NC DEPARTMENT OF
**HEALTH AND
HUMAN SERVICES**

November 20th, 2023

RE: Food Lion #1237
133 Mittie Haddock Drive
Cameron, NC 28326

This letter acknowledges review of the remodel plan for the above referenced establishment. The plans received on 09/14/2023 application, and specifications including email correspondence are approved with the following conditions and comments:

1 REVISED FIXTURE PLAN  
A1.01 SCALE: 3/32" = 1'-0"

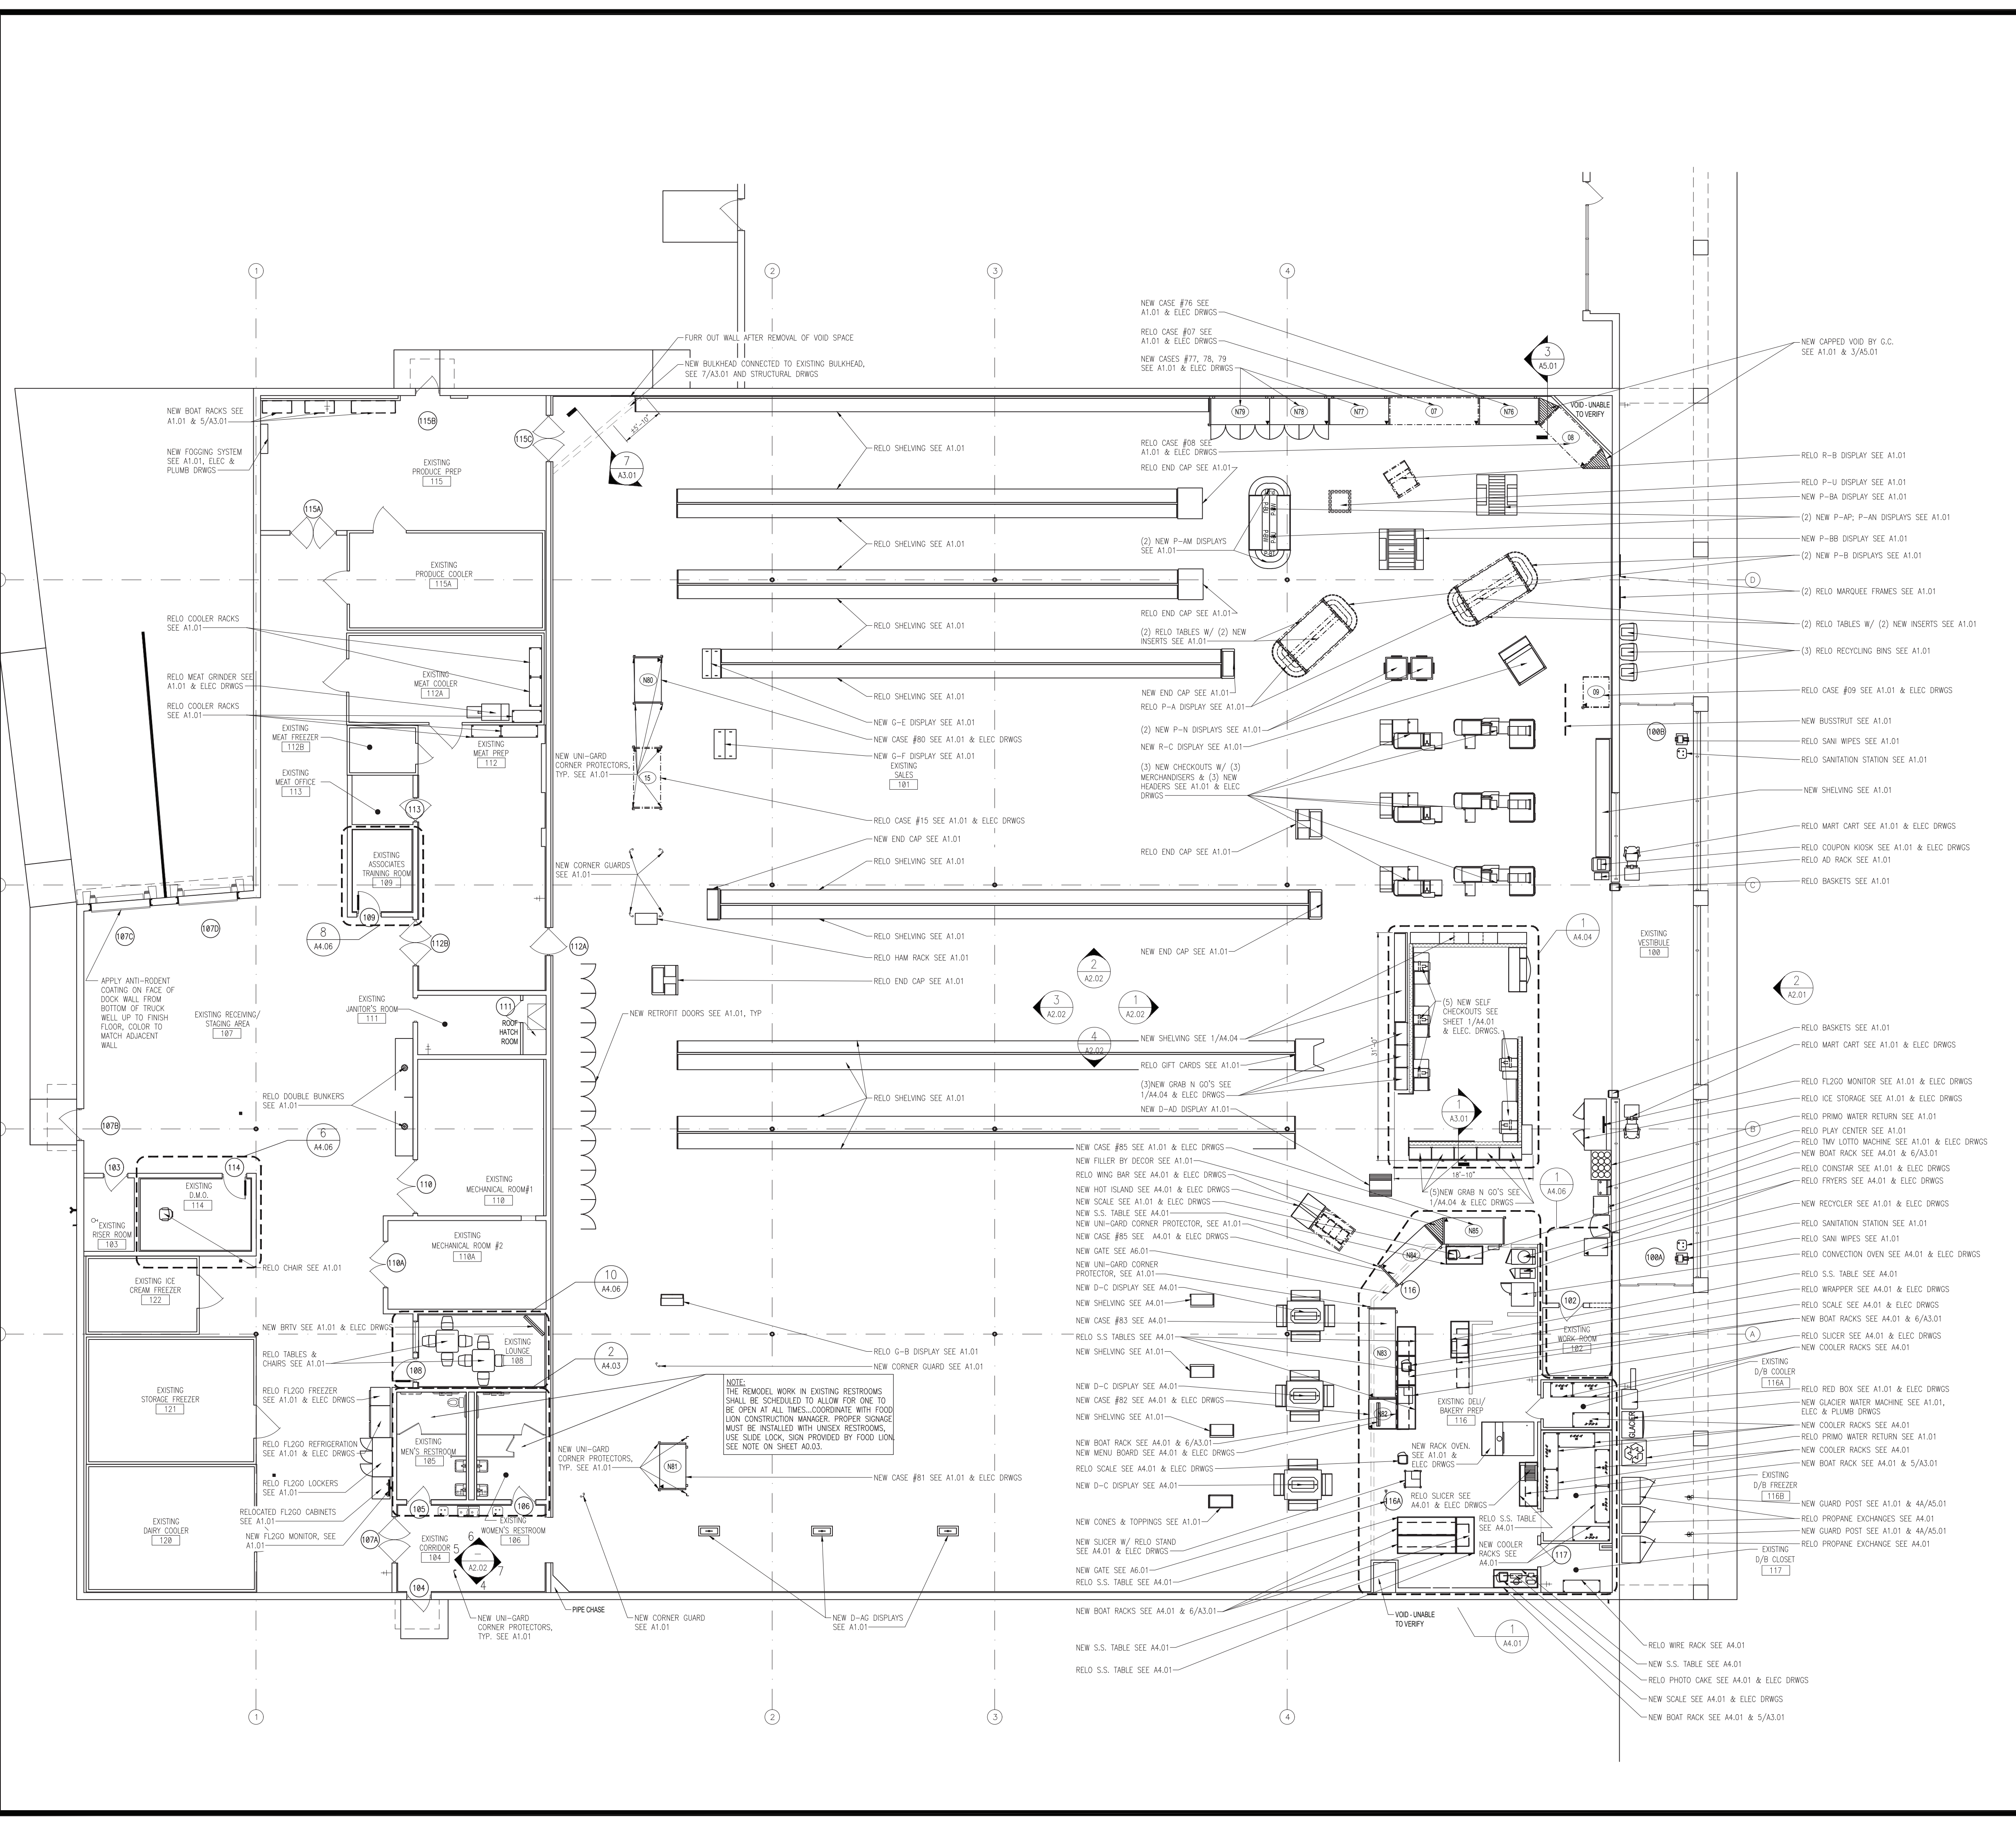
1. The scope of work covers the addition of new and relocated equipment in the Deli/Bakery Prep/Sales Areas. The installation of new equipment on the revised equipment plan and scope of work (attached with the email approval) was noted as follows: hot and cold deli cases, boat racks, cooler racks, shelving, stainless tables, *oven, and a hot island bar.

*Please note any new, existing, or relocated ovens and fryers will need to be installed under the hood in accordance with the local building code, as well as meeting all requirements listed in the equipment specification sheets.

In addition, specific equipment will be removed or relocated as part of the remodel as indicated on the scope, application, and revised plan. (attached with this approval letter email)

3. Updated food equipment must comply with Section 4-205.10 of the North Carolina Food Code and be installed as specified in Sections 4-402.11 and 4-402.12. The grinder in the Meat Department is shown as relocated to the cooler, indicated in the scope of work. (Please see 2a & b for details below.) All other existing equipment, and fixtures remain approved, and with this understanding; the revised fixture plan is approved.
